KIRKLEES METROPOLITAN COUNCIL INVESTMENT & REGENERATION SERVICE

DELEGATED DECISION TO DETERMINE PLANNING APPLICATIONS

Reference No:	2023/62/93410/W
Site Address:	Sycamore Lodge, 41, Broad Lane, Upperthong, Holmfirth, HD9 3XE
Description:	Erection of dormer extensions to create first floor living accommodation, alterations to fenestration to rear elevation, erection of balcony and alterations to external staircase
Recommending Officer:	Lucy Taylor

Officer Report.

230426-P-A112

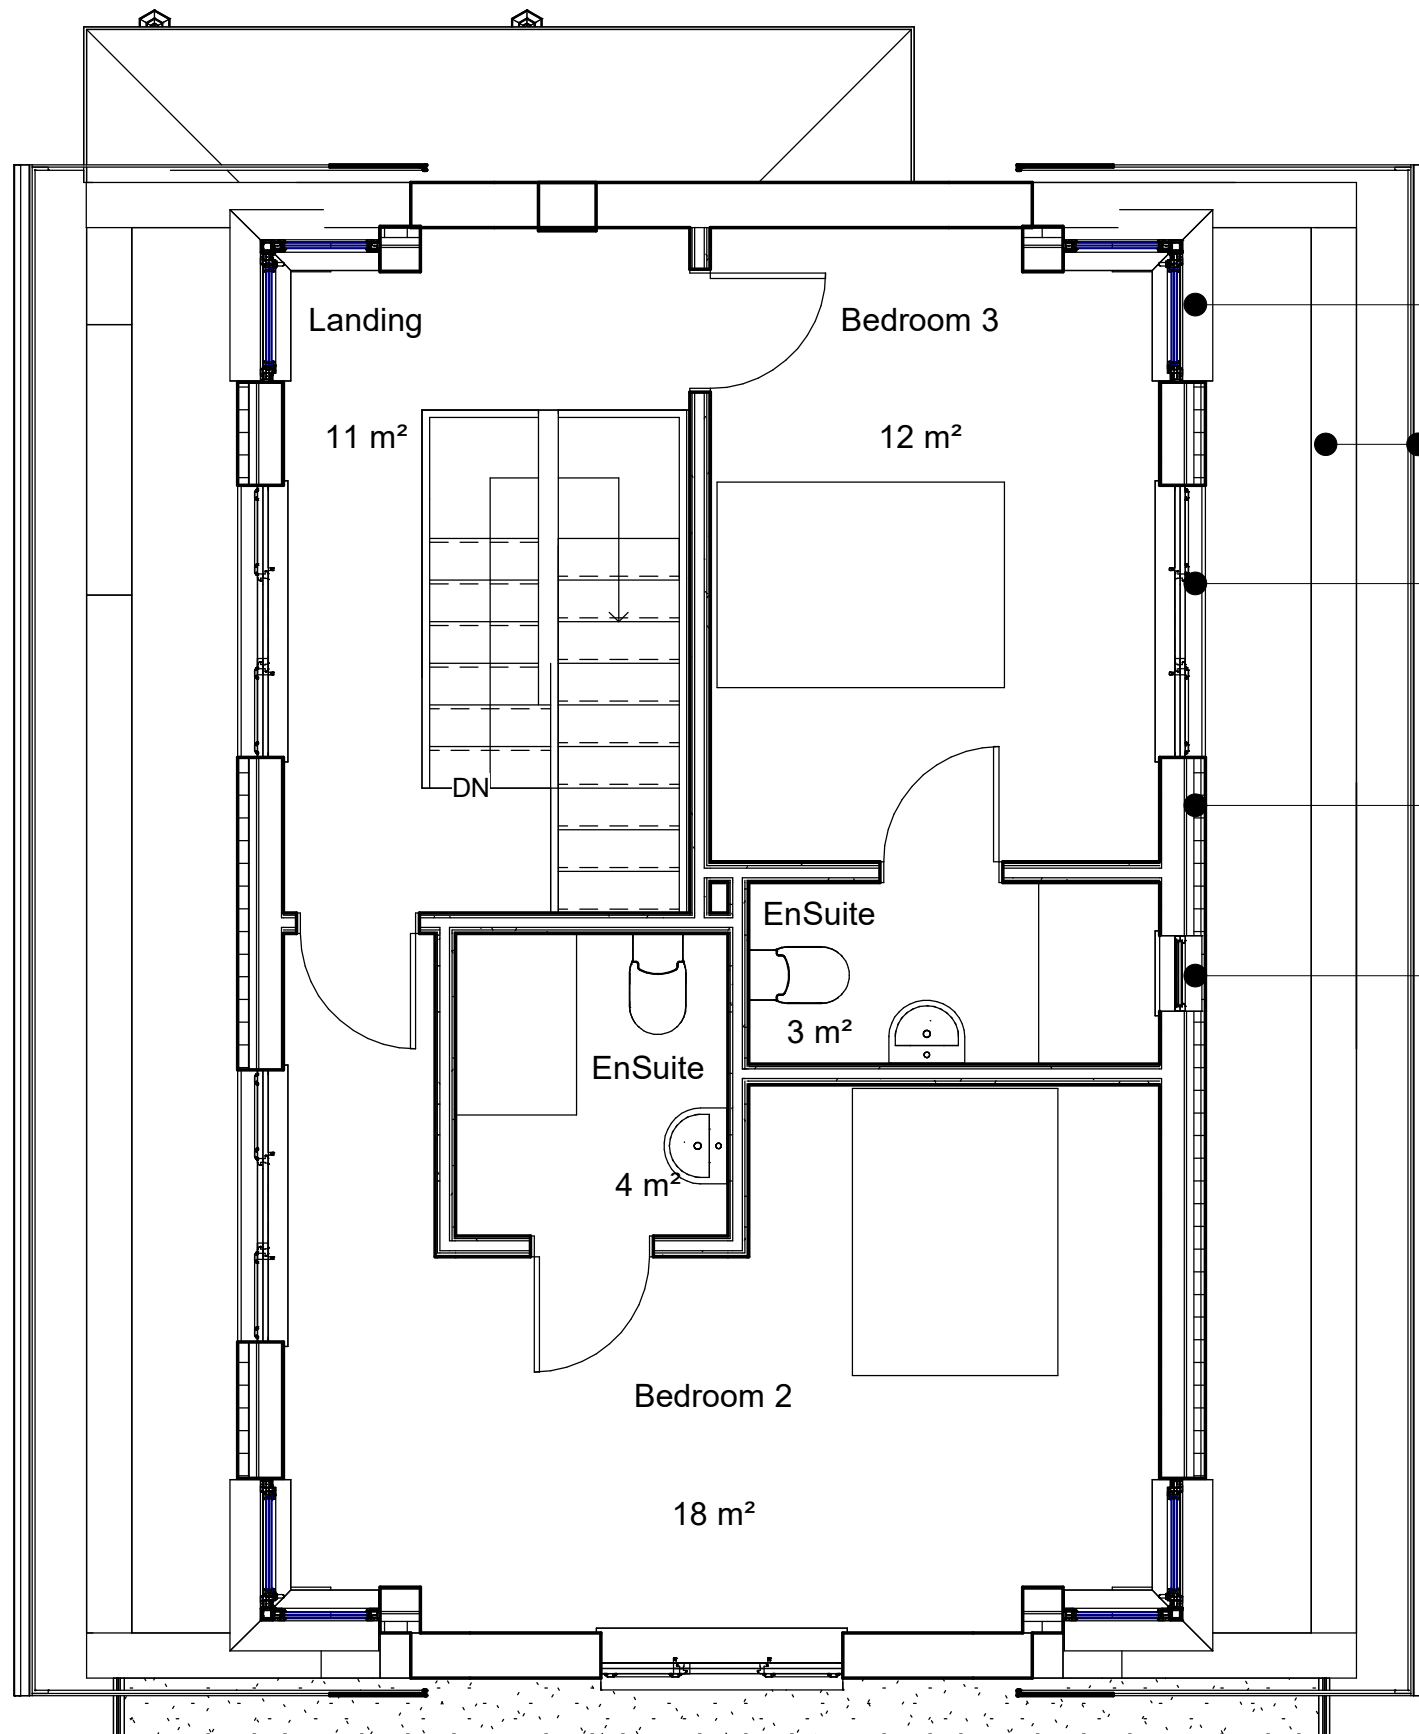
The submitted plans annotate that, the windows to the western facing dormer that face towards neighbour elevations would be double-glazed and opaque, with these opening windows to be fitted with 100mm cam stays. Dwg No. 230426-P-A112 shows annotations to windows that will be installed as such.

Whilst the front corner window is not shown to be opaque glazed or fit with 100mm cam stays, this is considered to be acceptable, with the only window on the eastern side elevation of No. 43 Broad Lane considered to serve the kitchen, classified to be non-habitable.

The eastern facing dormer is not annotated to denote that any of the windows within this dormer would be opaque. This is considered to be

acceptable, with the windows in this elevation not considered to result in any undue impacts of overlooking, with the only window in the western facing elevation of No. 39 Broad Lane obscure glazed. The windows in the dormer would be set back approximately 3 metres from the siting of the rear conservatory at No. 39.
